Application by Awel y Môr Offshore Wind Farm Limited for an Order Granting Development Consent for the Awel y Môr Offshore Wind Farm project

The Examining Authority's written questions and requests for information (ExQ1) Issued on 27 September 2022

DRAWING NUMBER: 004262401-06
 APFF: 5 (2) (1)
 Sheet No: 5 of 11

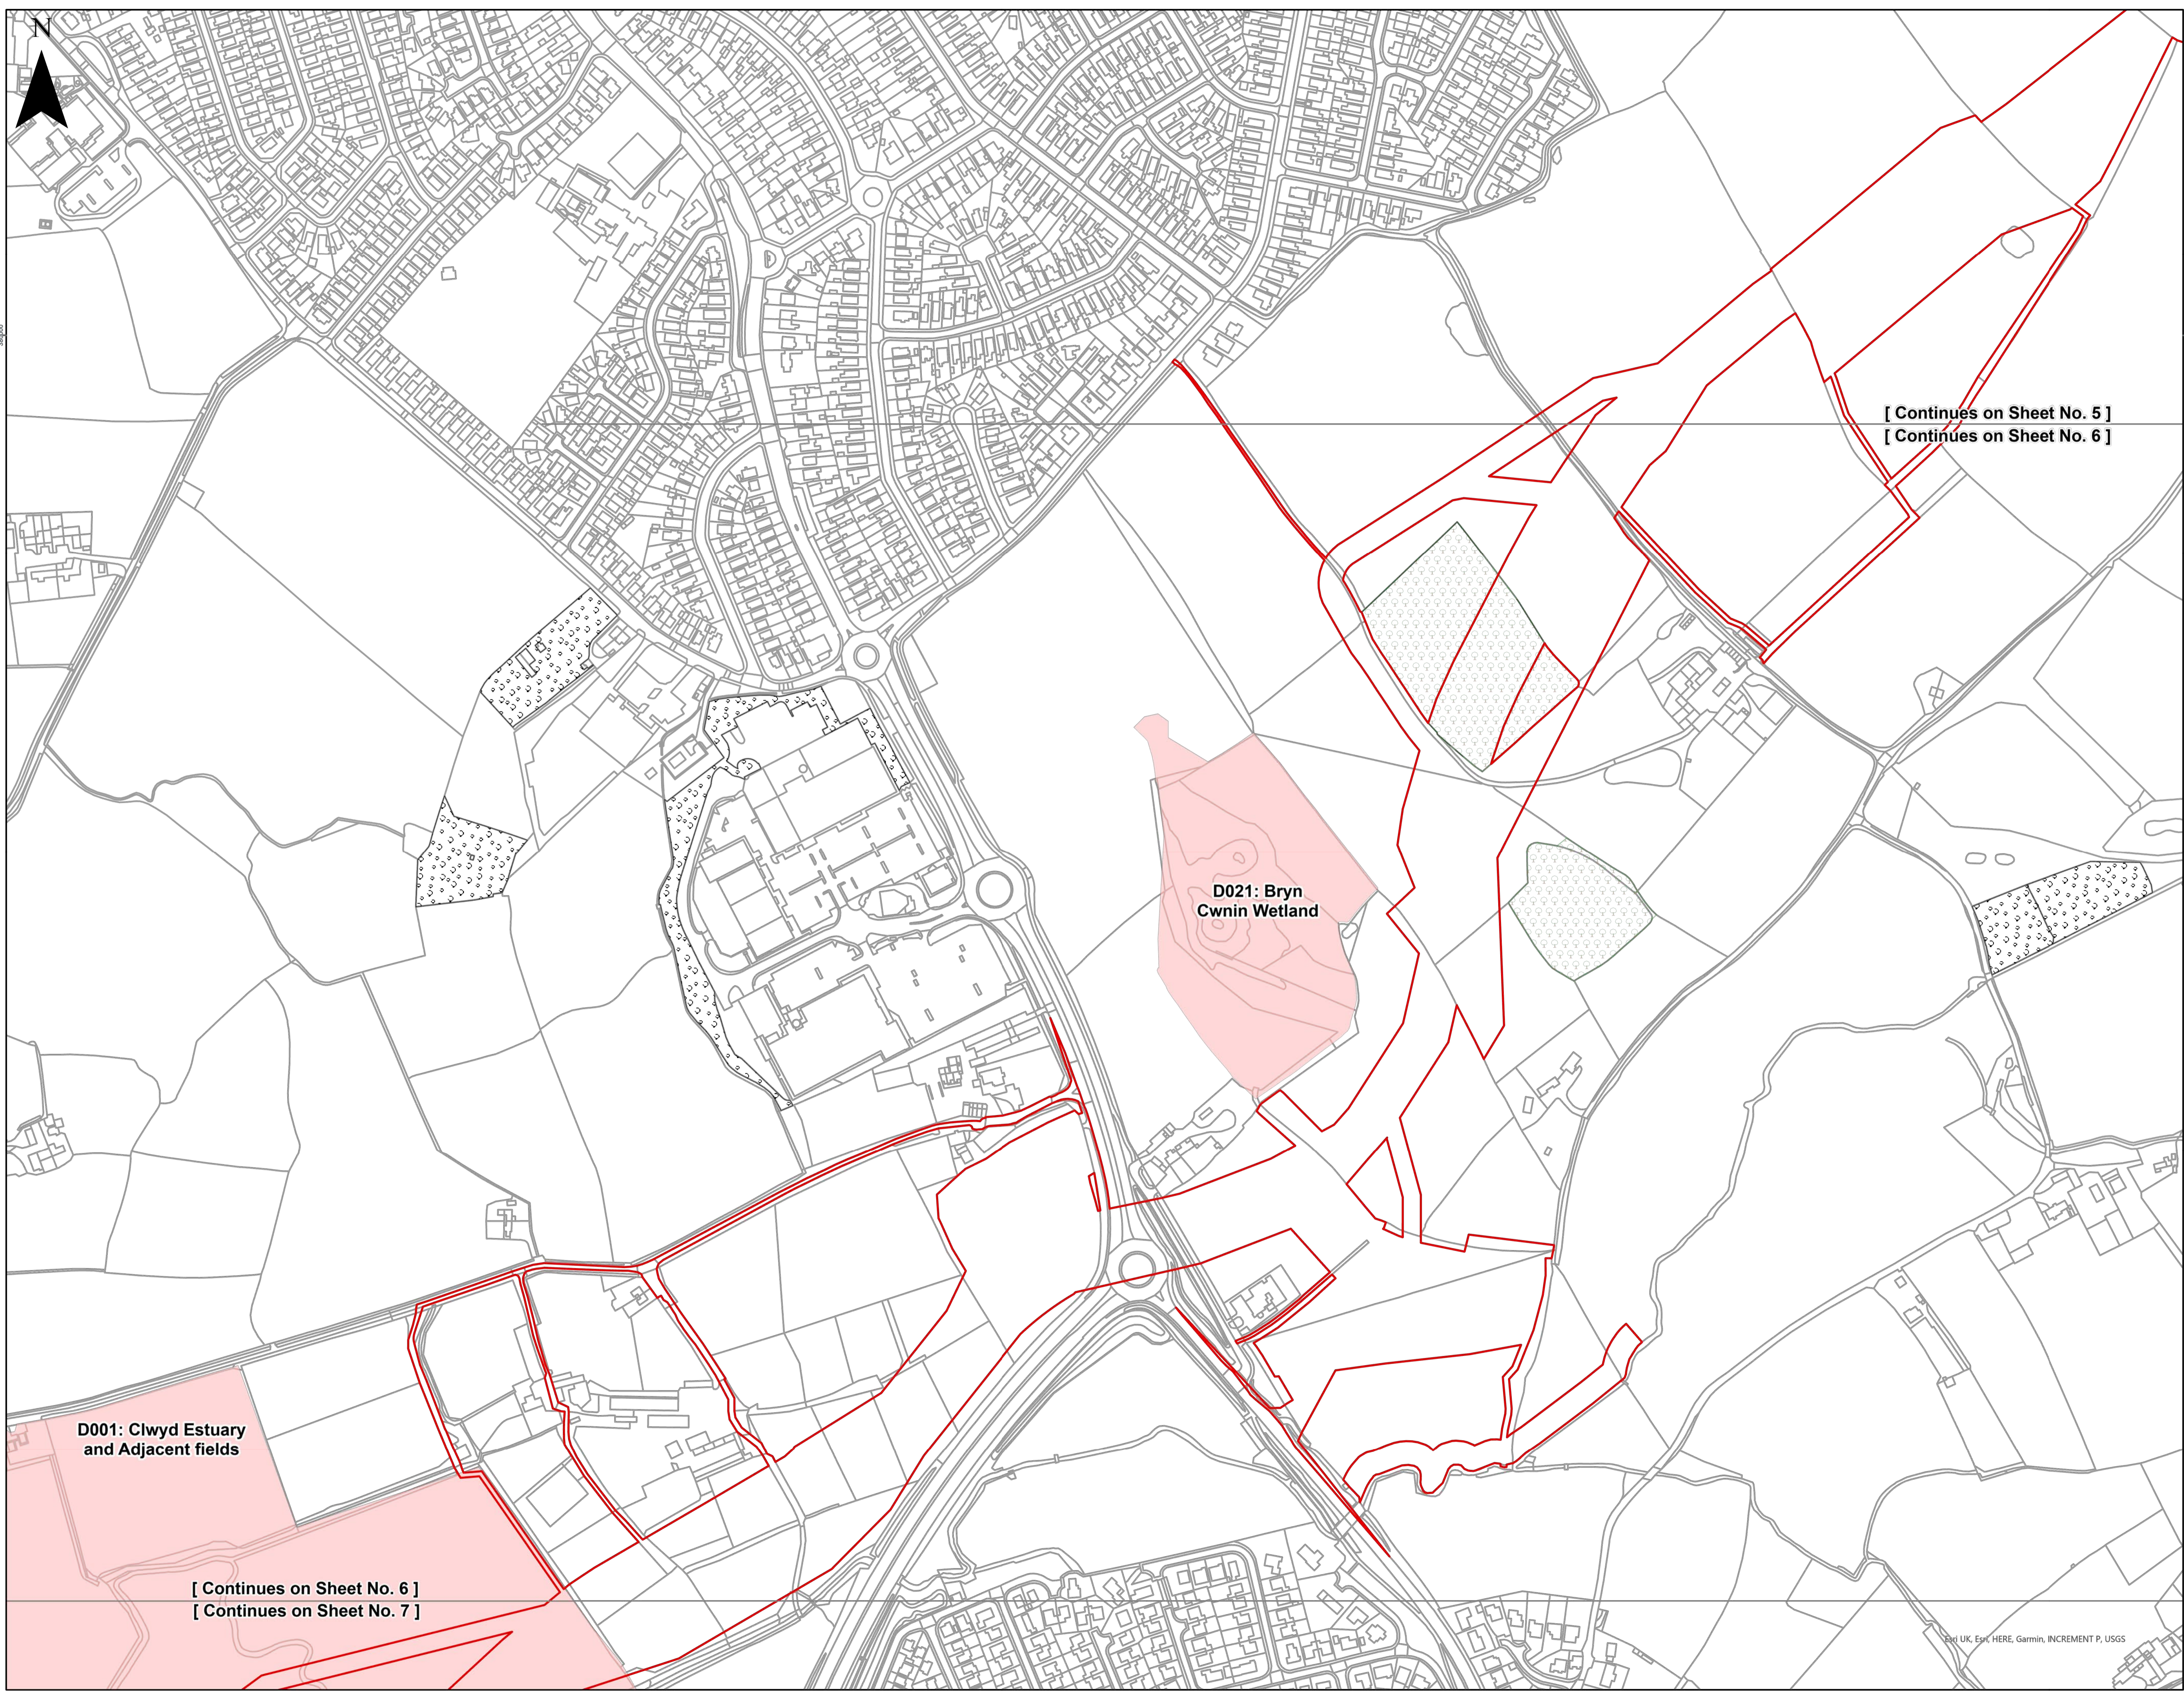
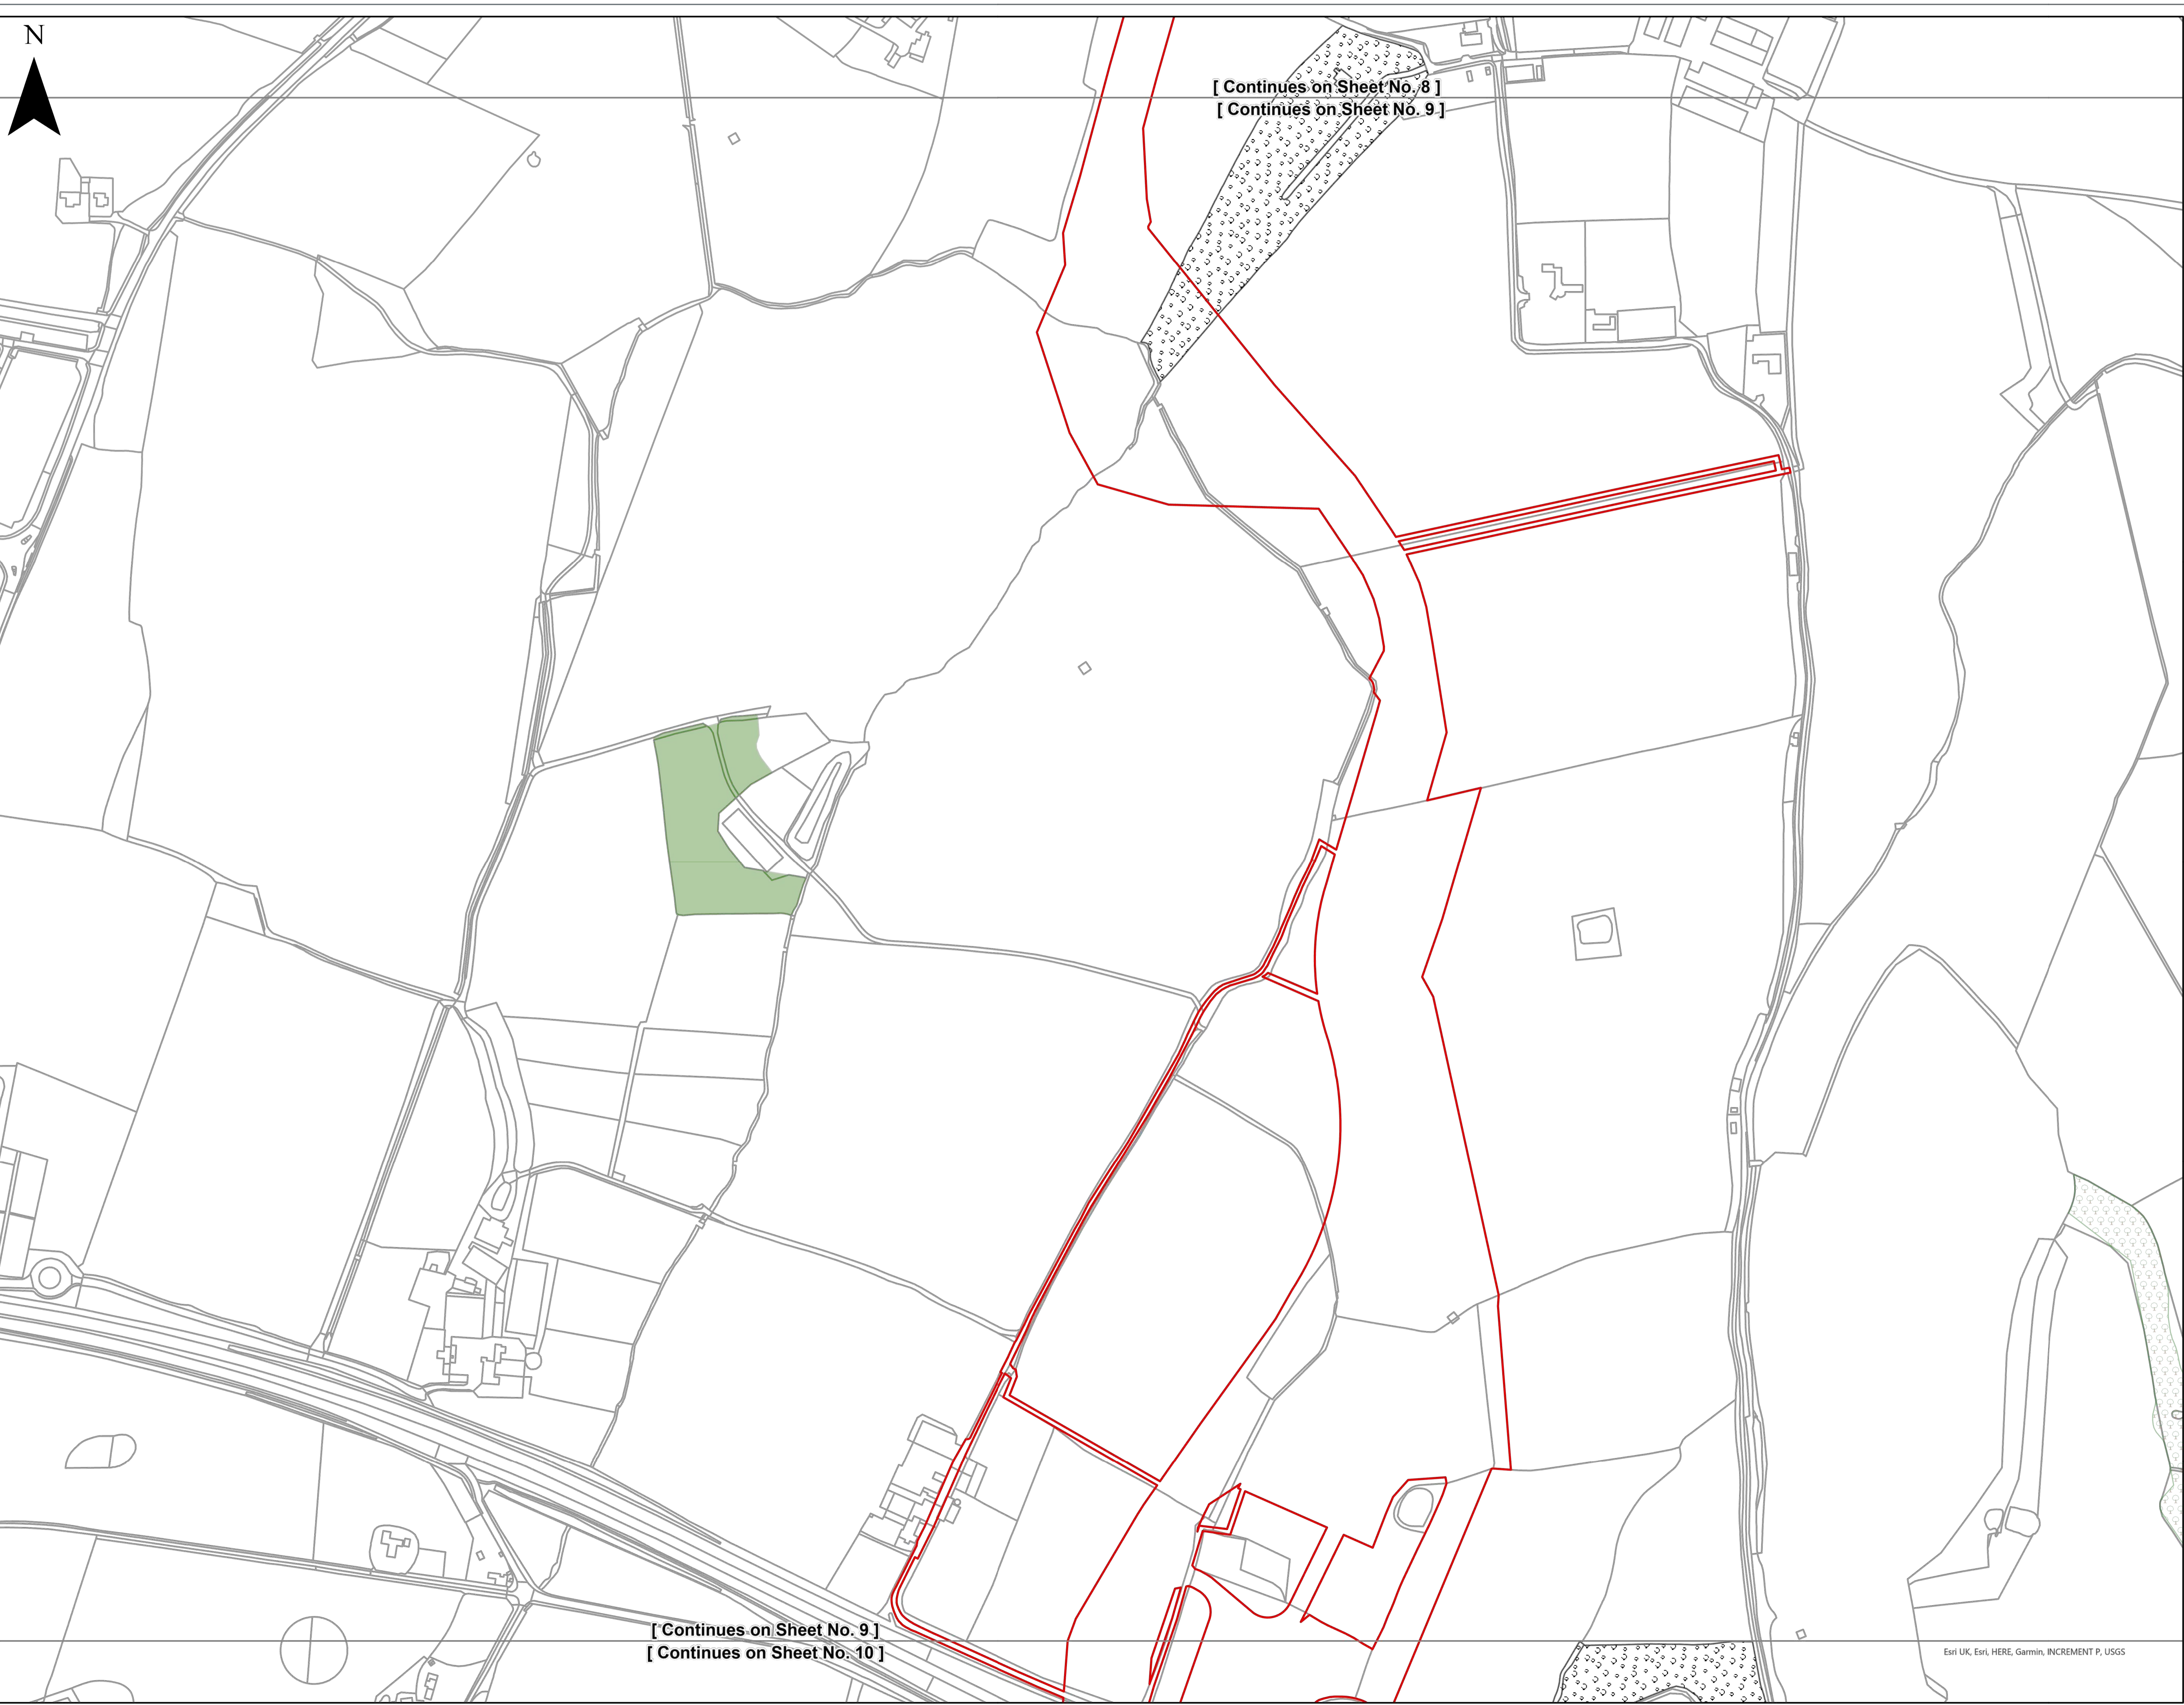
2.7	The Applicant	General Statutory / Non-statutory Nature Conservation Sites Plan [AS-010] Please can you address the following points: <ul style="list-style-type: none">a) Sheet 1 of 11 - The legend does not reflect all hatch colours shown and the extents of SPA hatch appears to be different on sheets 2 and 3;b) Sheet 2 of 11 –does the drawn shape and extent of Local Wildlife Sites at western edge reflects y Ffrith D011;c) differentiate the woodland area to help identify other ancient semi-natural woodland, plantation on ancient woodland site and local other woodland;d) label the name of the other nature reserves on the relevant sheet.
